Please ask for: Nicola Moore
Email: nicola.moore@arun.gov.uk
Telephone: Ext 37944
Our Ref: M/131/21/CLP
Your Ref:
Date: 12th October 2021

Lawful Development Certificate for a Proposed Use or Development

Development: Lawful development certificate for the proposed replacement of rear conservatory with single storey extension.
Location: 3 Juniper Close Middleton-On-Sea PO22 6SD

Proposed Ground Floor
1 : 100

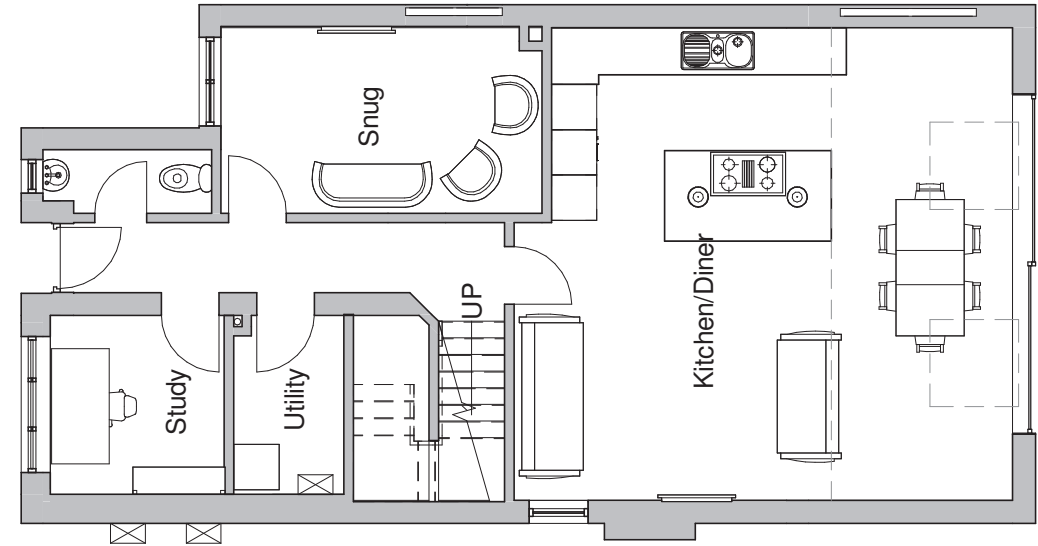
The proposed floor plans show the garage being converted. For clarity, please confirm if this is to be included in the application.
